OUT19/12069

**Vickery Mine Extension (SSD-7480)
Response to Submissions**

Detailed advice to DPIE Planning & Assessment regarding the Vickery Mine Extension (SSD-7480) Response to Submissions

Please refer to Figure 3 for the alluvial boundaries and the Western Emplacement.

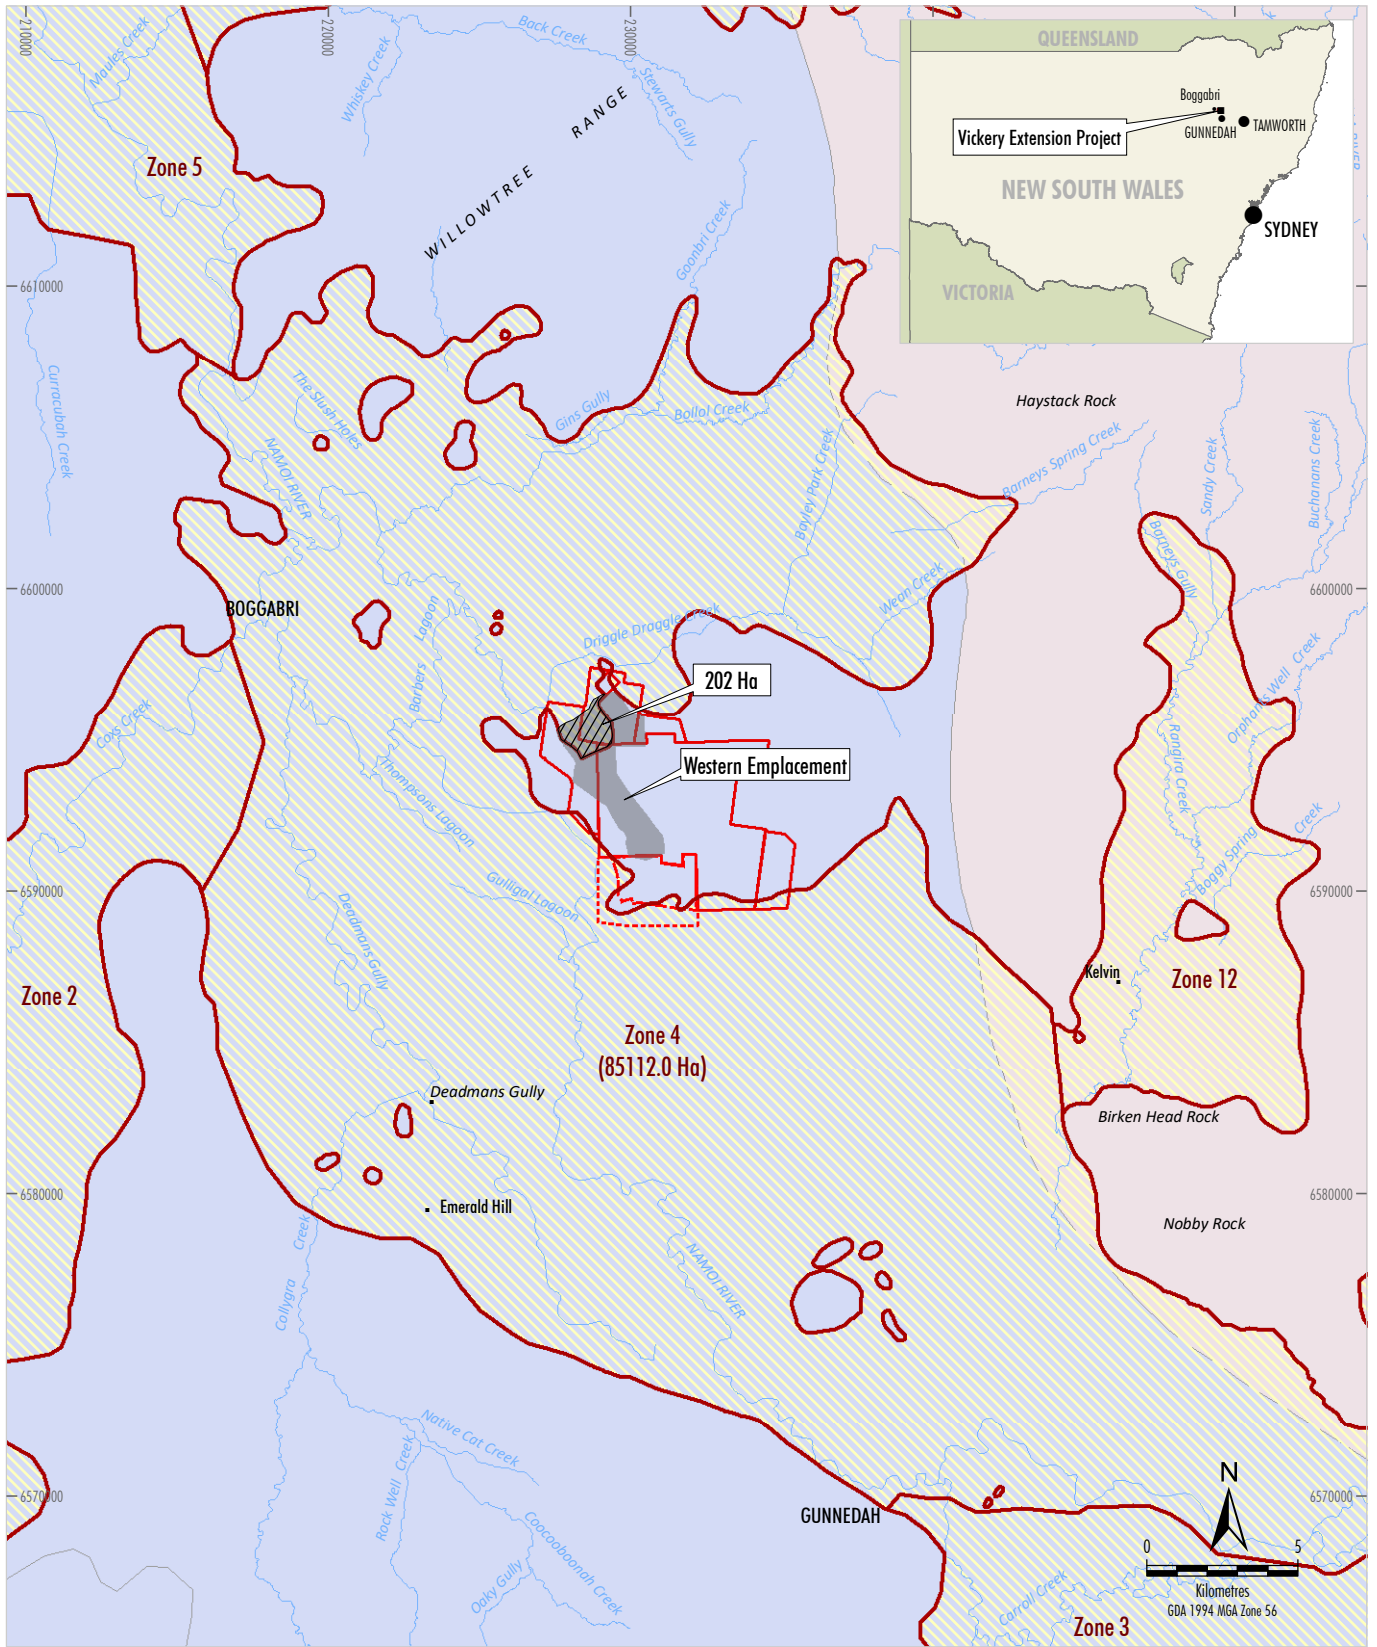
- With respect to the stockpile:
 - The proponent is required to map the proposed stockpile locations in relation to the alluvial boundaries. Figure 3 in the RTS must be updated with this information.
 - The proponent is required to address compaction of the alluvium in relation to extent and loss of storage.
 - The proponent is required to address water quality risks including baseline, lateral extends, duration, risk to receptors to the alluvium as a result of the emplacements that overlie or are adjacent to the alluvium.
 - The proponent is required to clarify any measure in place to mitigate the risk of the stockpile to the alluvium.
